MID-WESTERN REGIONAL COUNCIL
PO Box 156, MUDGEE NSW 2850
86 Market Street, Mudgee | 109 Herbert Street, Gulgong | 77 Louee Street, Rylstone
T 1300 765 002 or 02 6378 2850 | F 02 6378 2815
E council@midwestern.nsw.gov.au

19 October 2023

**SUBJECT: Advice on Amendments to the Environmental Impact Statement;
Birriwa Solar Farm SSD-29508870.**

BARNEYS REEF ROAD UPGRADE

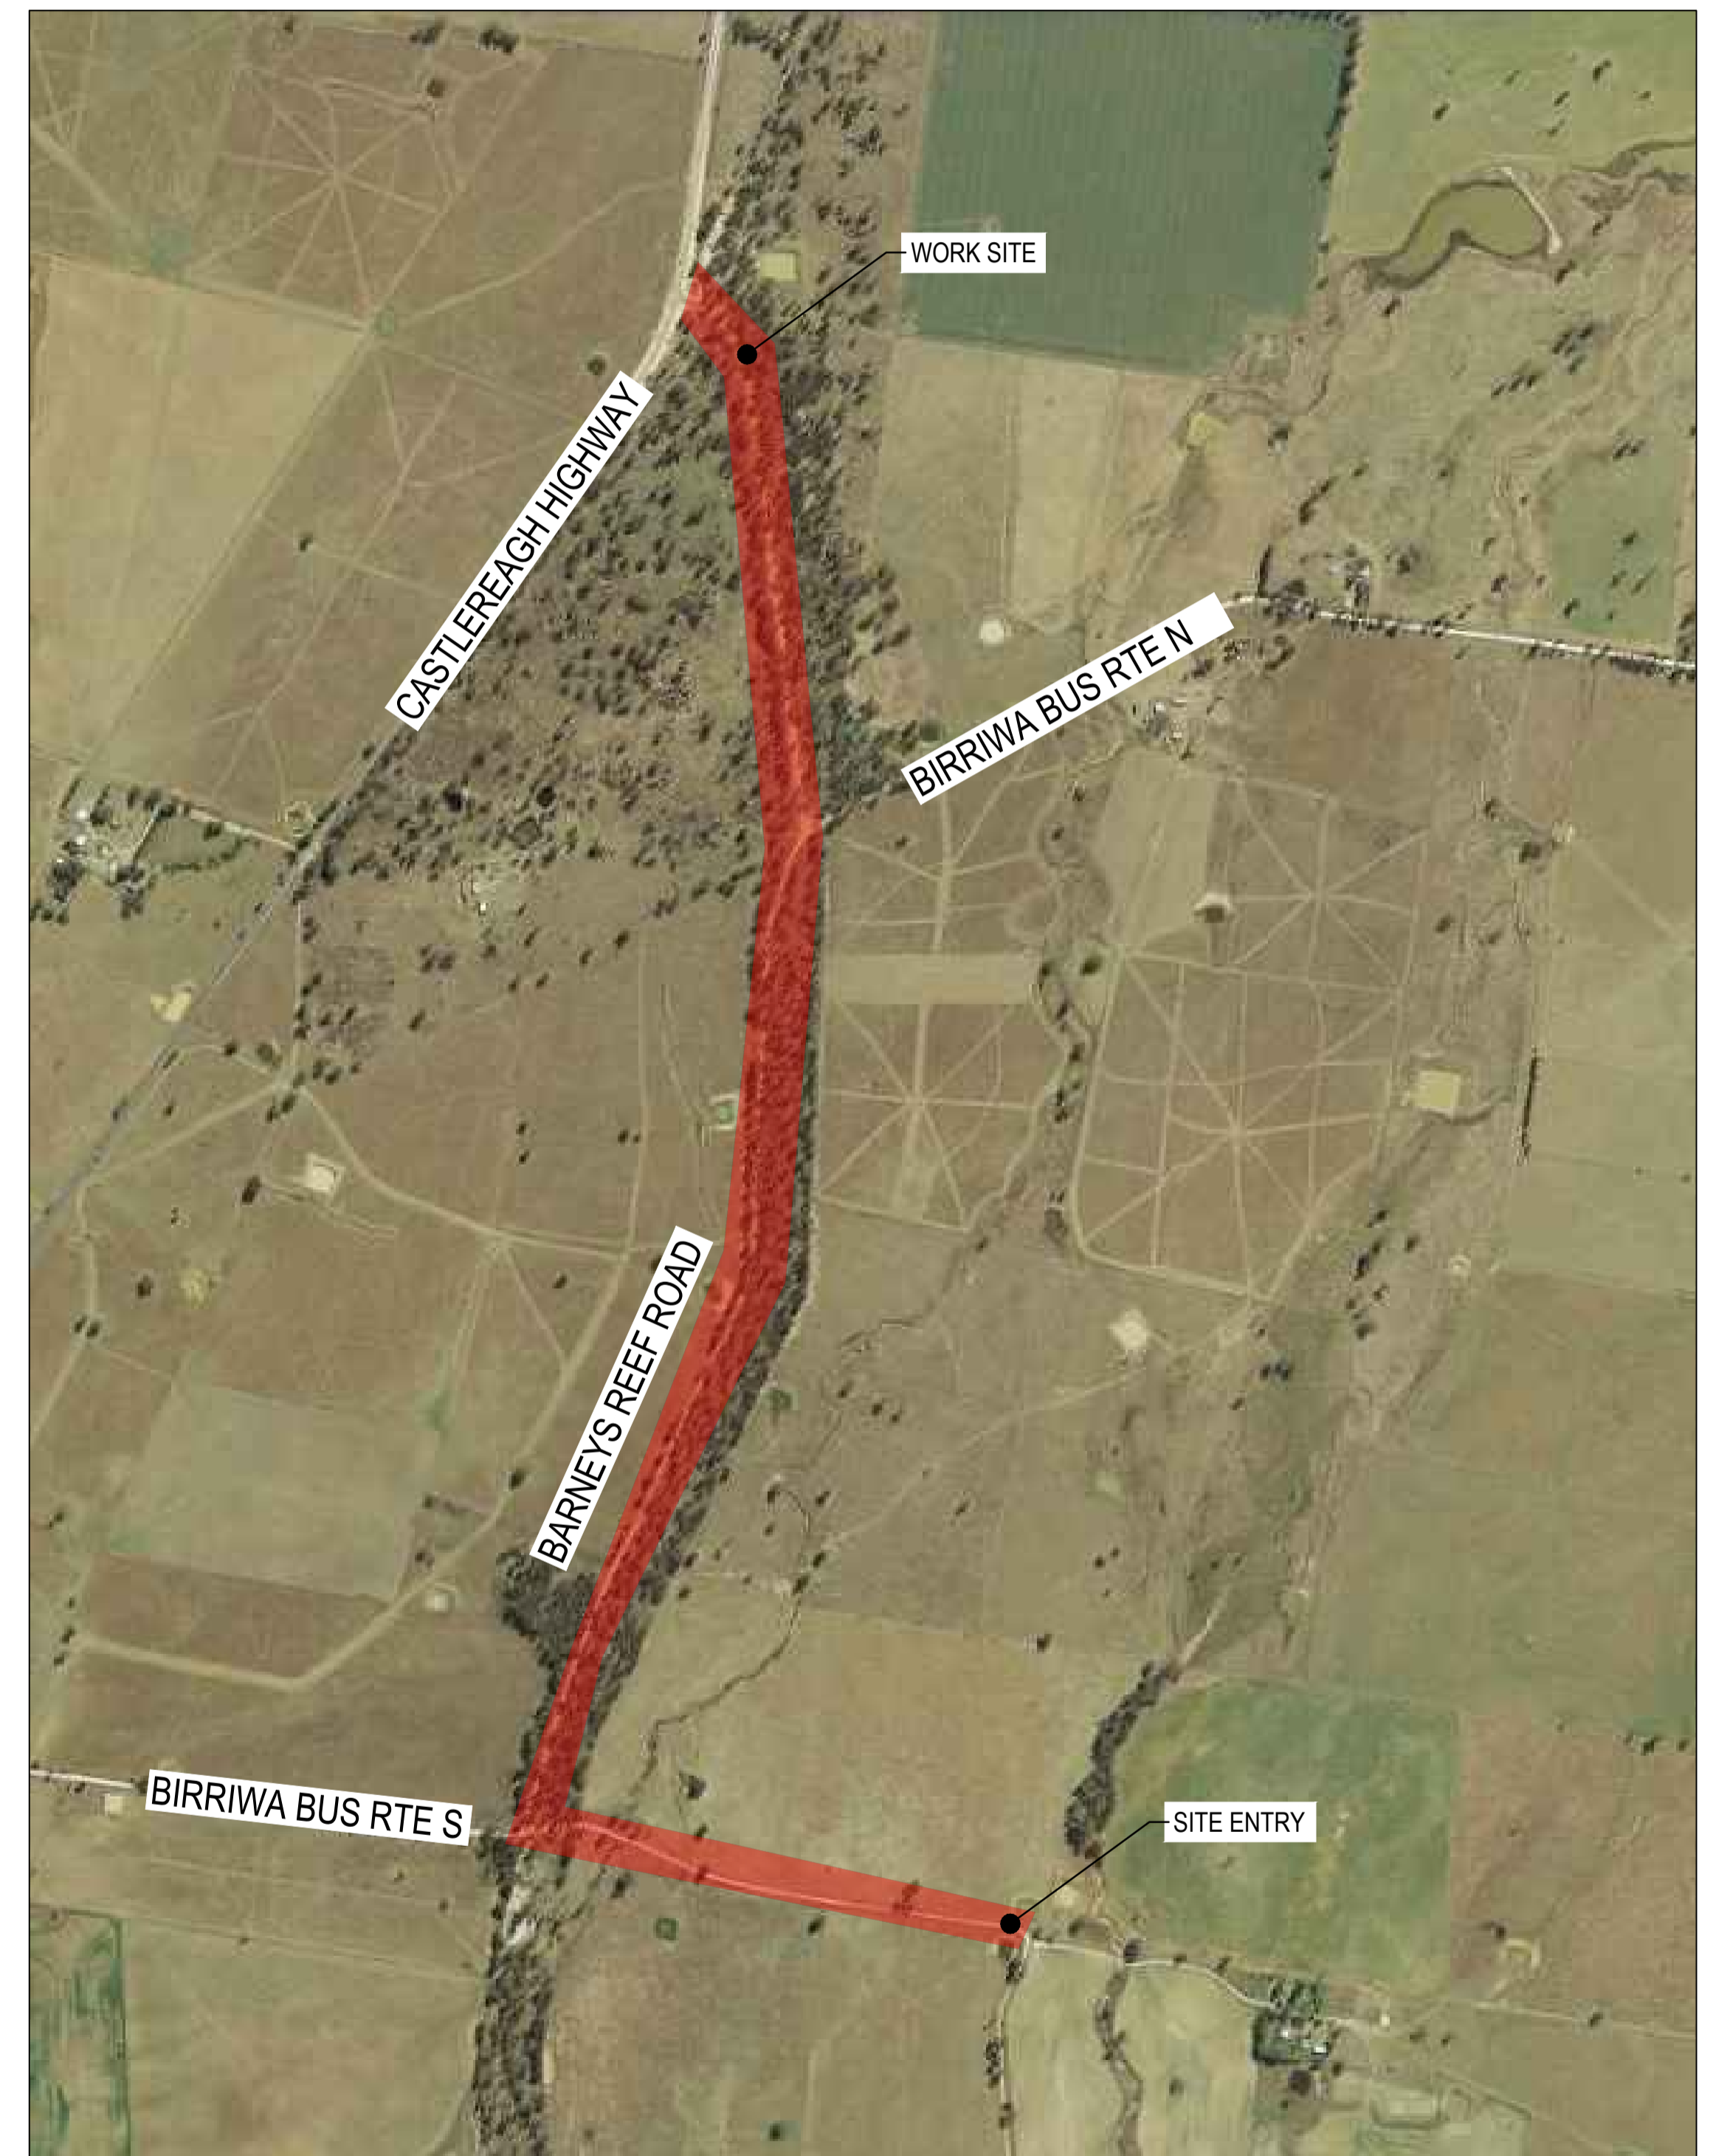
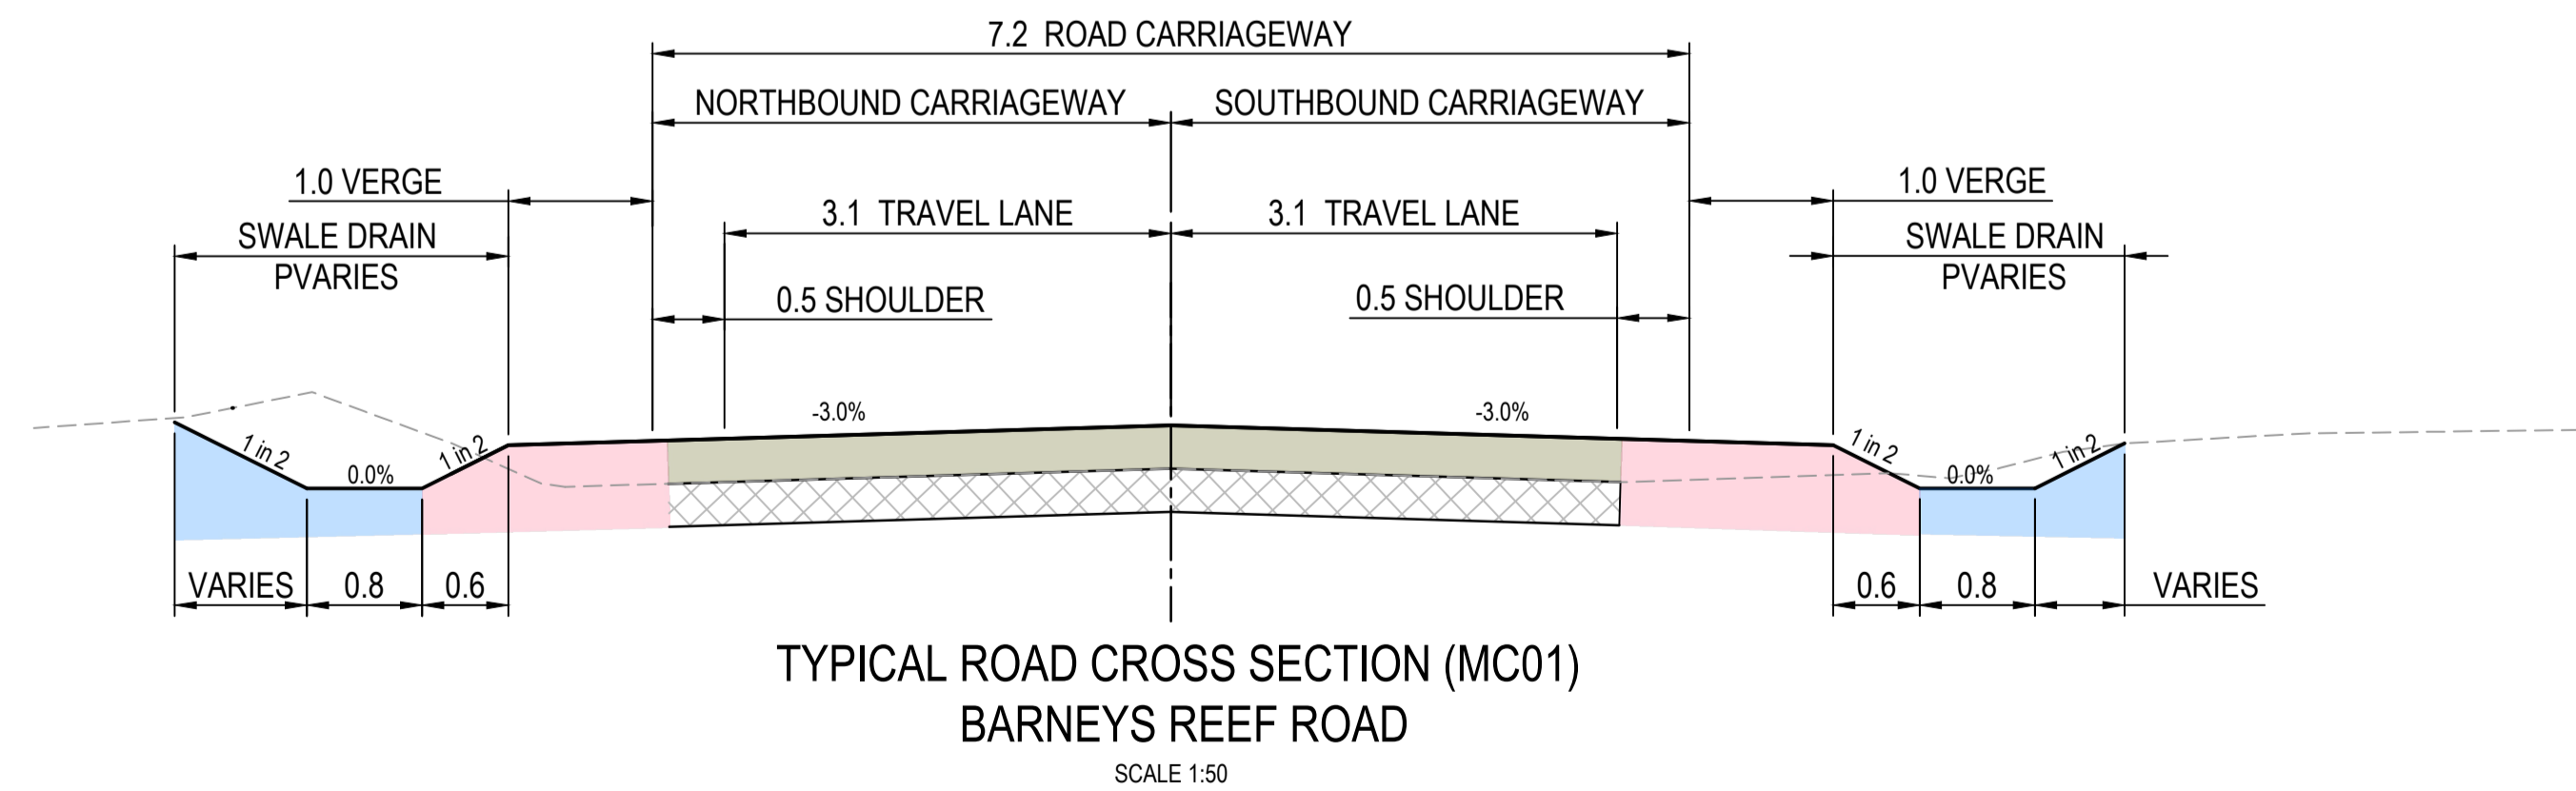
EIS Appendix C design (REJECTED)

The proponent is required to amend this design and resubmit for correct road upgrade cross section in accordance with cumulative AADT as required above and Austroads Guide to Road Design Part 3 – 4.2.6 Rural Roads Table 4.5.

Intersection geometry to be amended, if required, in accordance with amendments required to EIS Appendix H and Appendix O noted below.
